Following your acceptance of the One Earth Solar proposals for examination and the recent hearings, South Clifton Parish Council (SCPC) wish to add to our registration comments.

As with our previous submission, we note that over 95% of our villagers' object to this application. SCPC voted unanimously to object at an open meeting on 23rd October 2023. Nothing since has changed that stance. This proposed 4,000-acre solar farm—larger than Newark-on-Trent (3,840 acres)—poses unacceptable and permanent impacts on our communities and environment. Villages within and adjacent to the order limits will be permanently affected, and it is our responsibility to speak out for future generations who will inherit these consequences after 60 years.

Outline Surface Water Drainage Strategy Plans

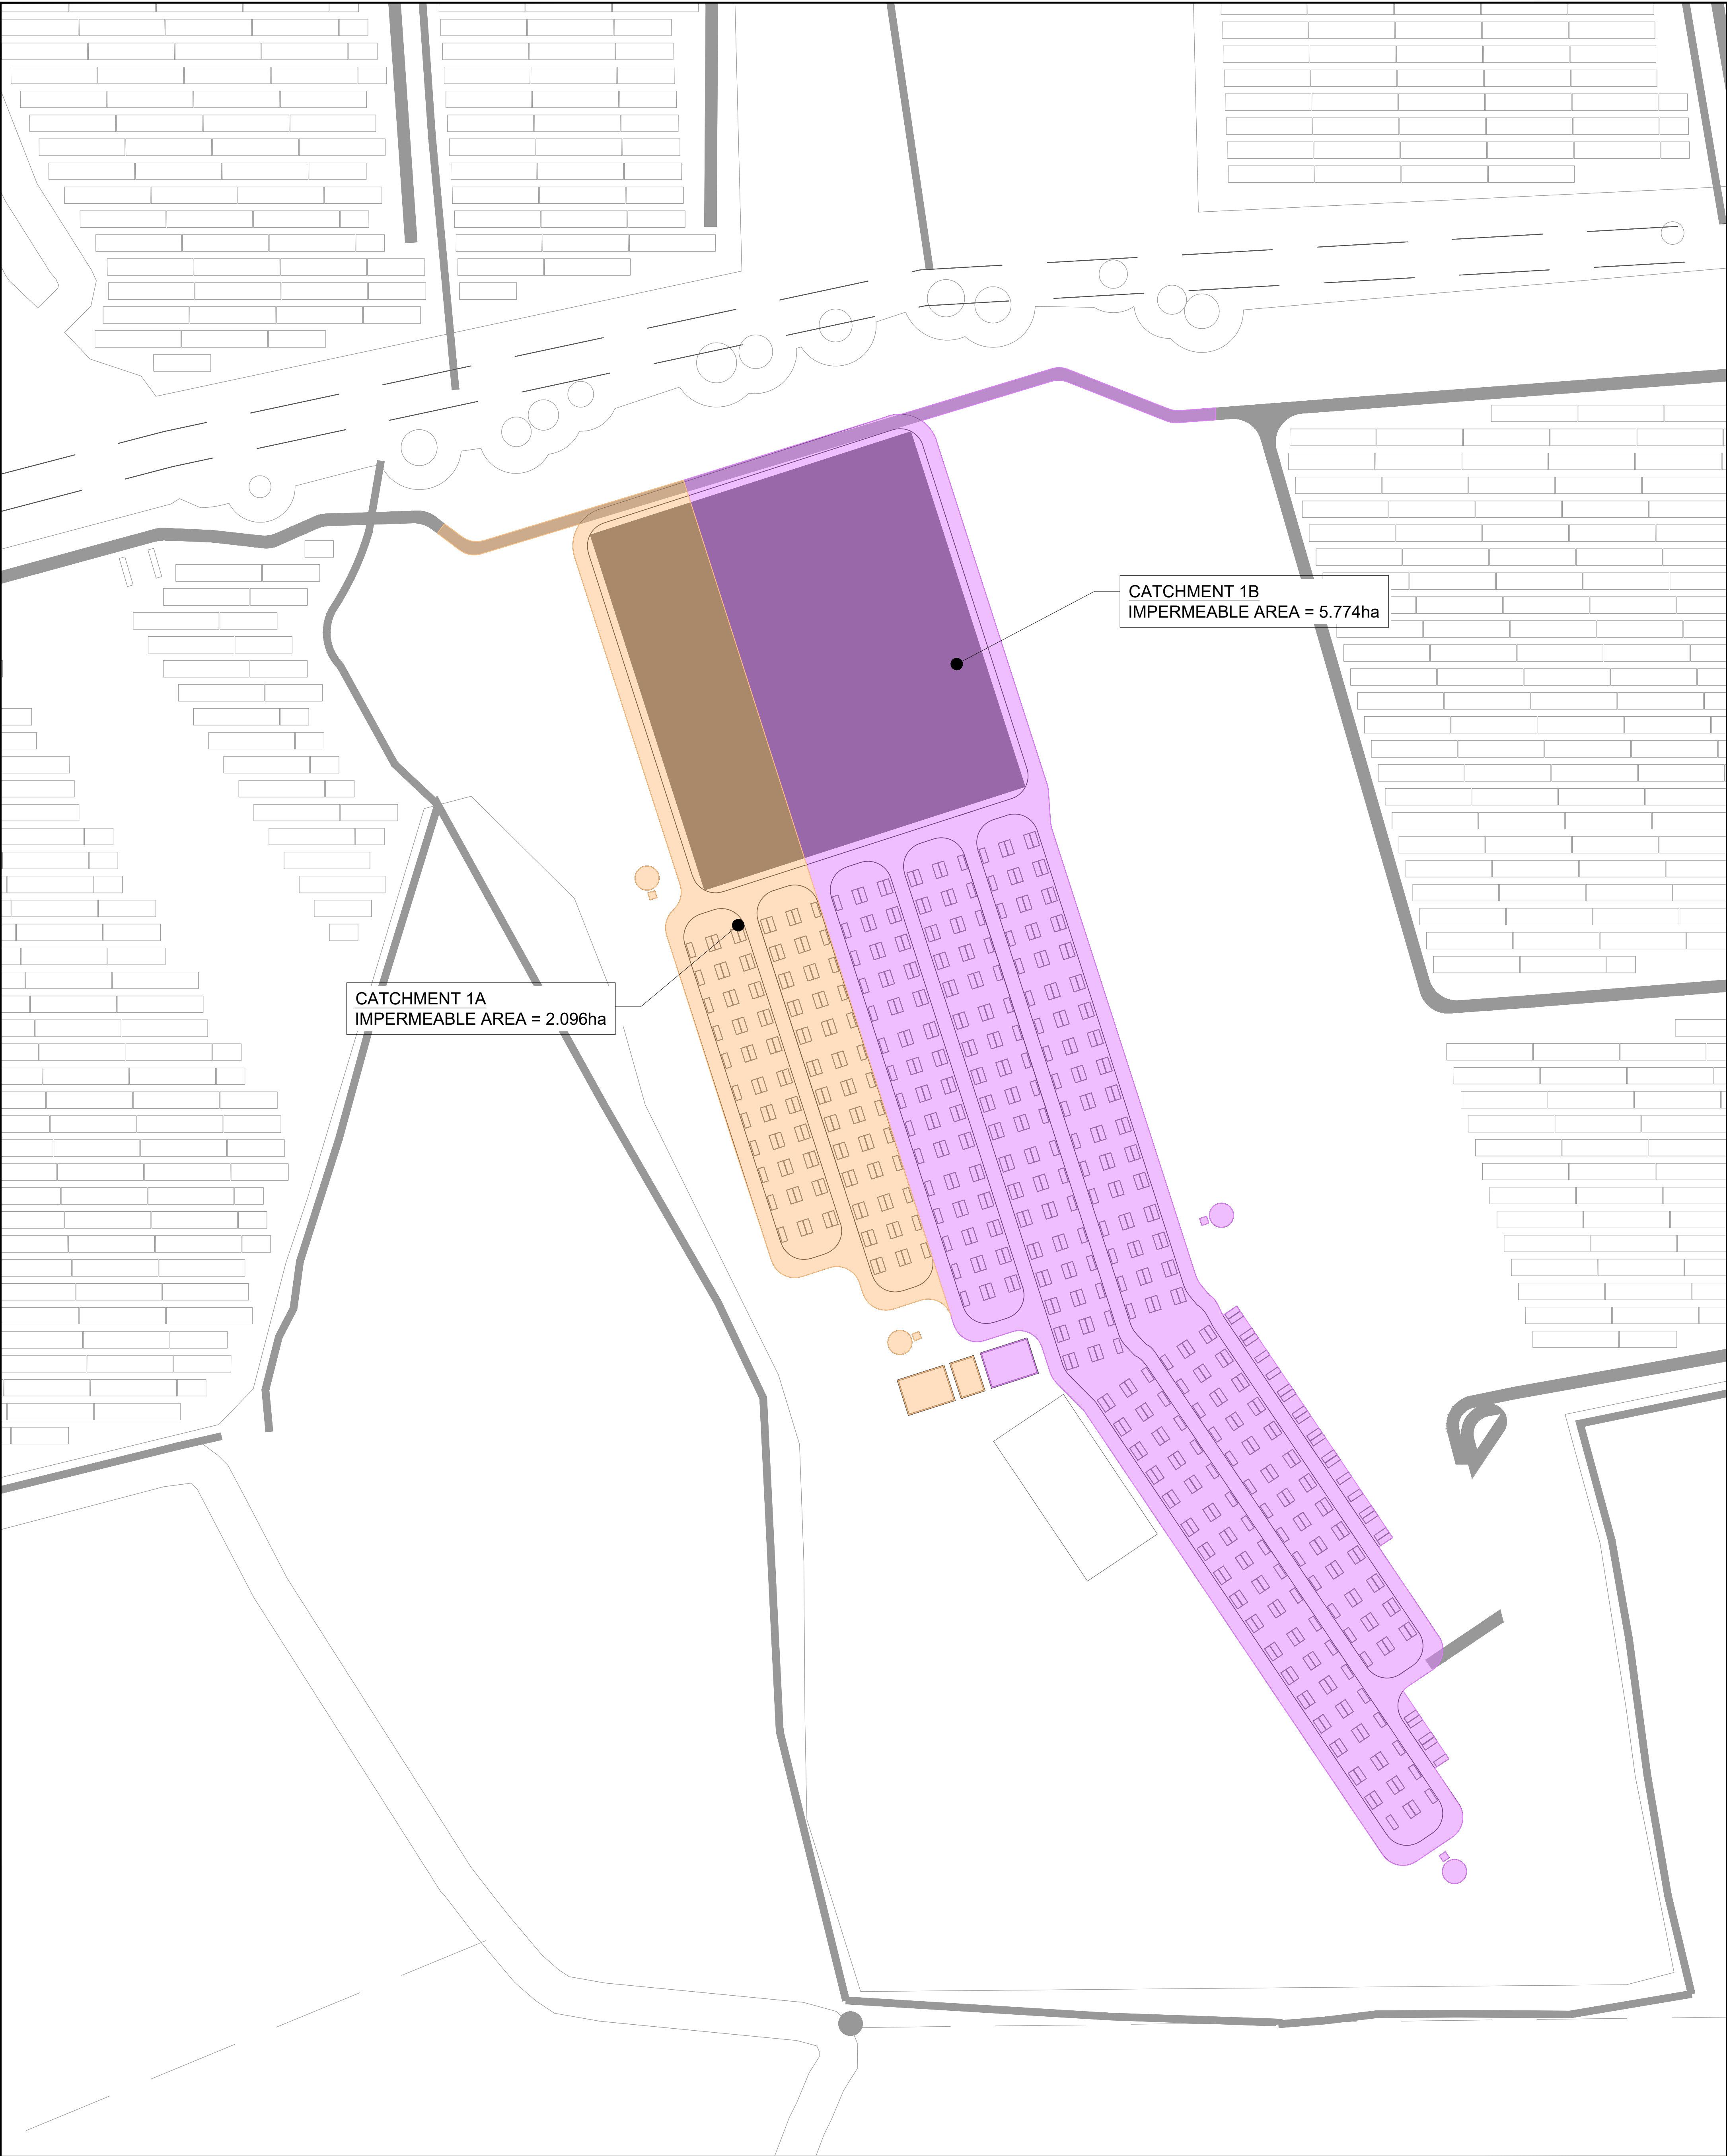
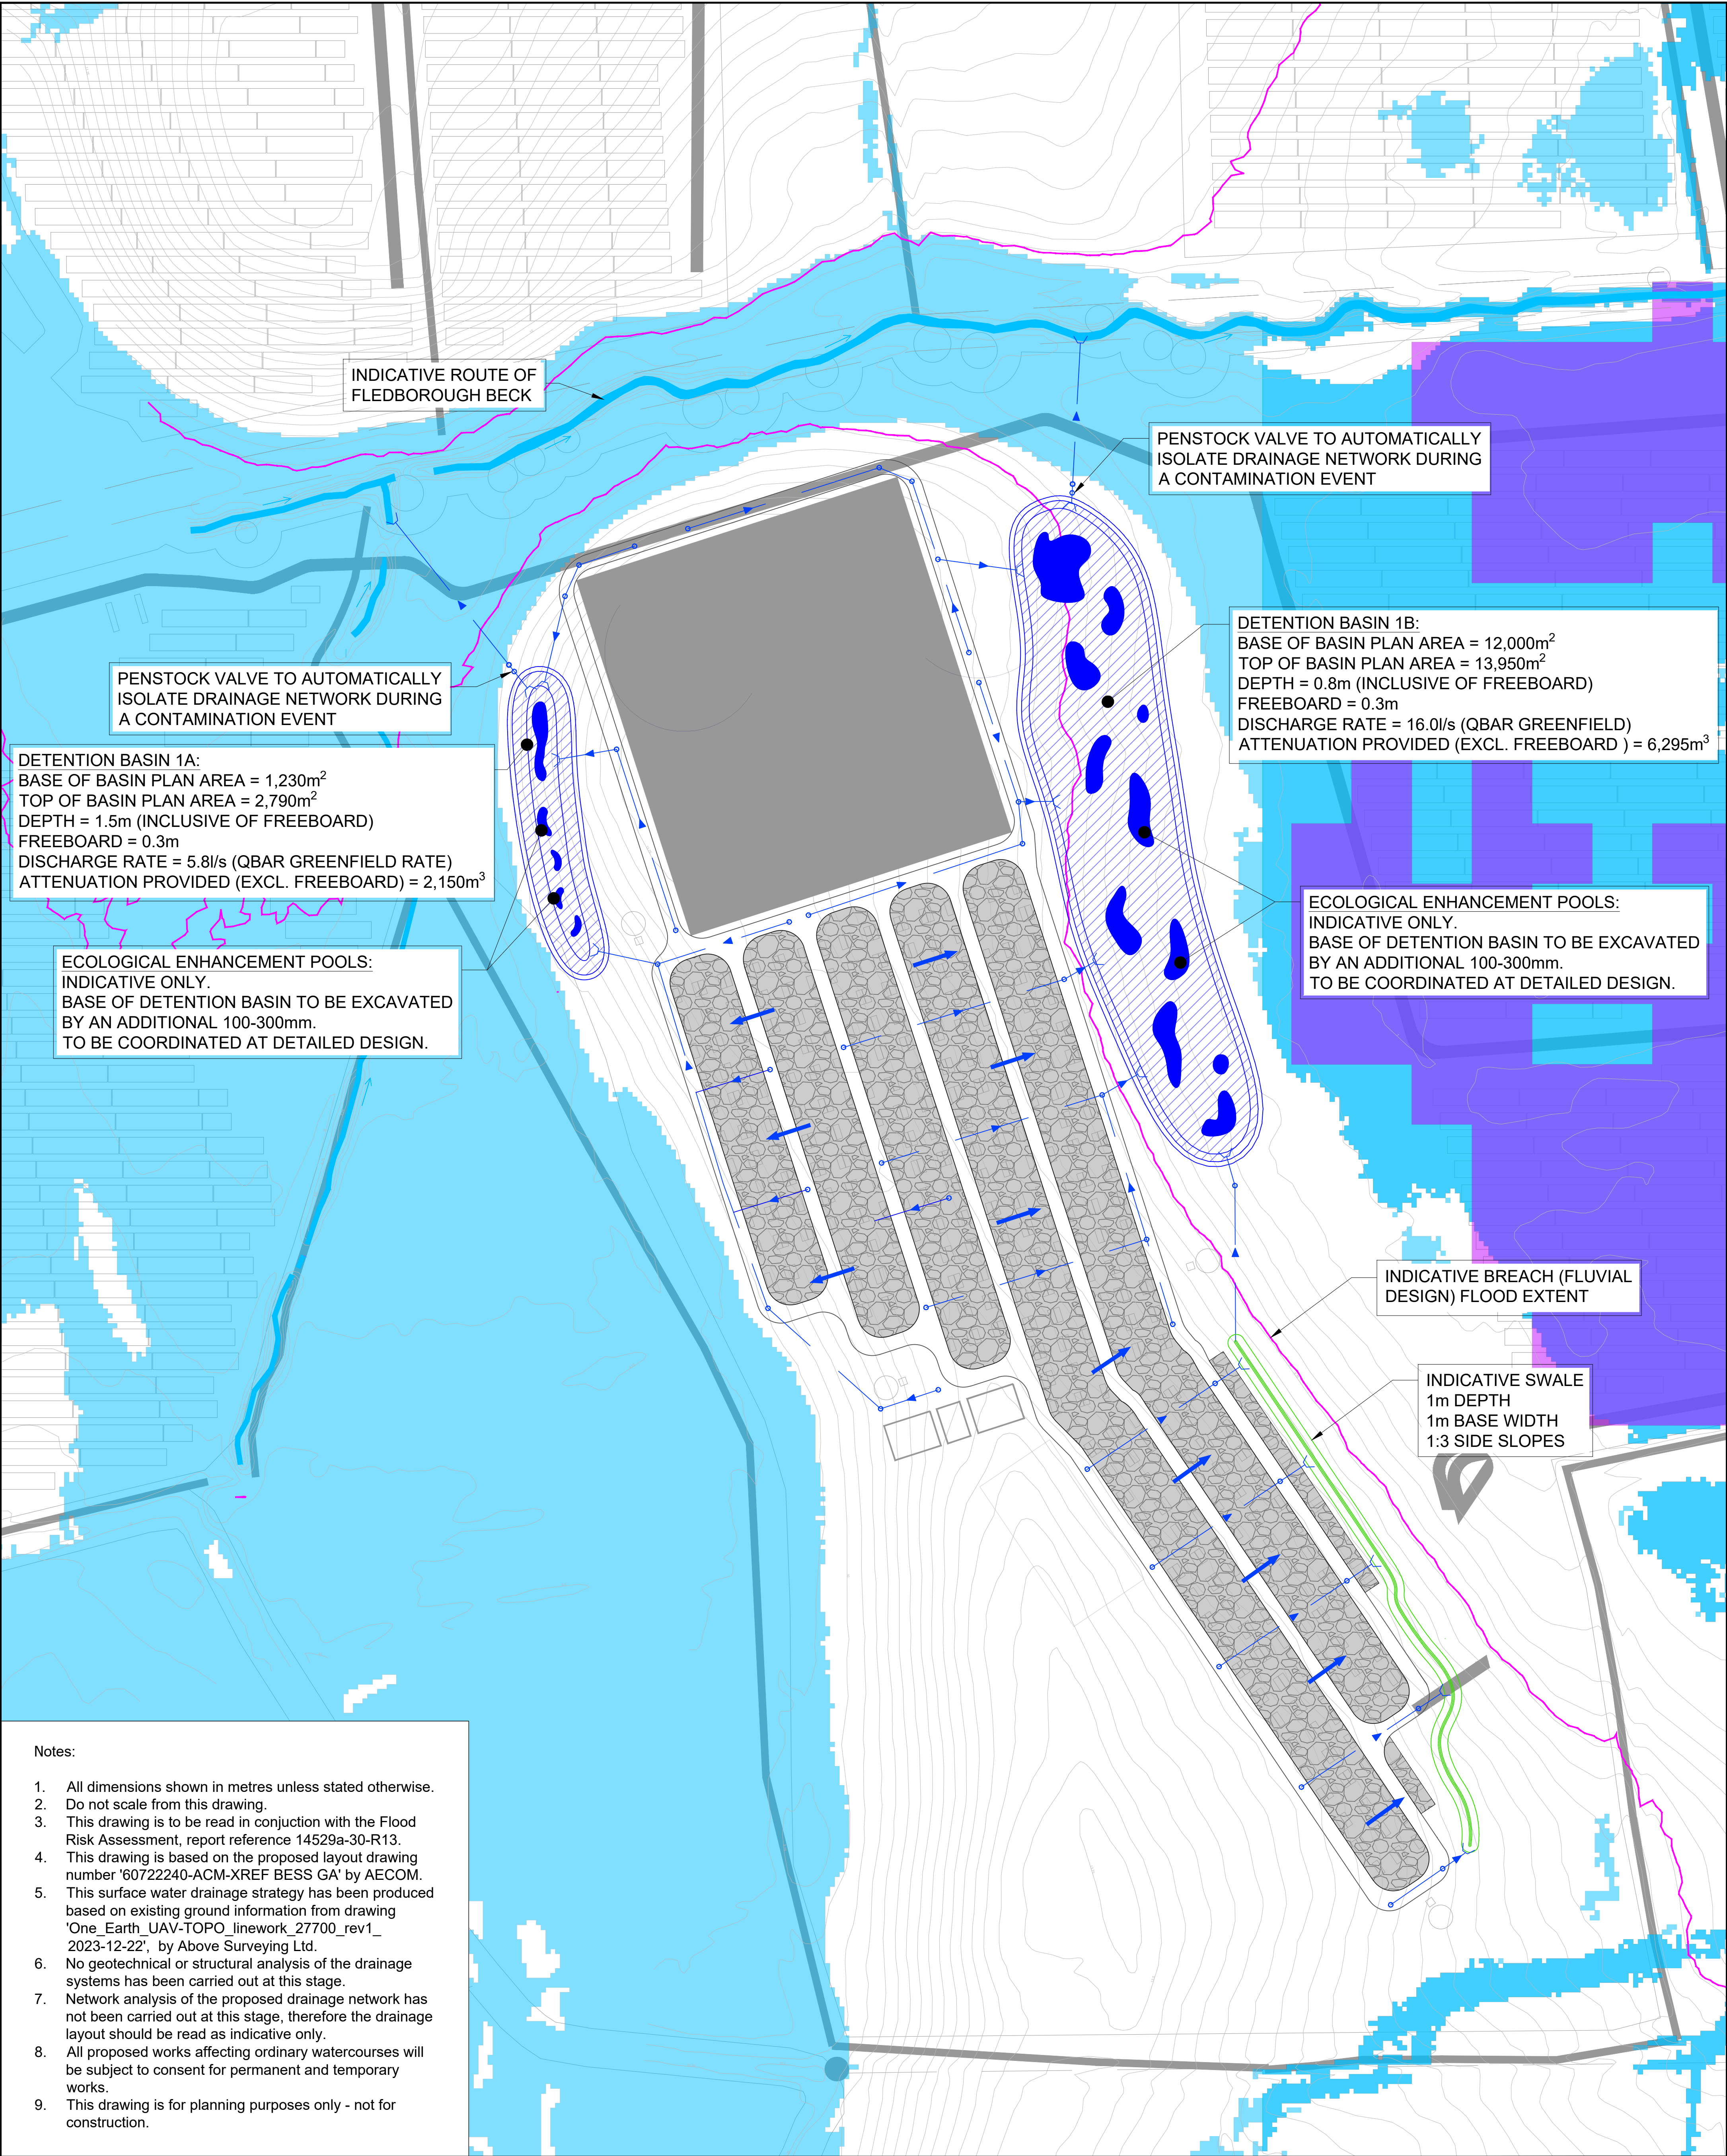
The site is at high flood risk, especially given the sandy soil. We support Action Points 32 and 33. Structures must withstand flooding, and North Clifton residents must be assured that panel fields will not worsen the situation. The Environment Agency's floodgate operations must be factored into a full hydrological impact analysis.

The adjacent Anglian Water Treatment plant and Hall reservoir must be considered. The applicant raised panel heights to mitigate flood risks, which could lead to panels as tall as double-decker buses. We await the plan detailing panel height variations and areas expected to be partially submerged.
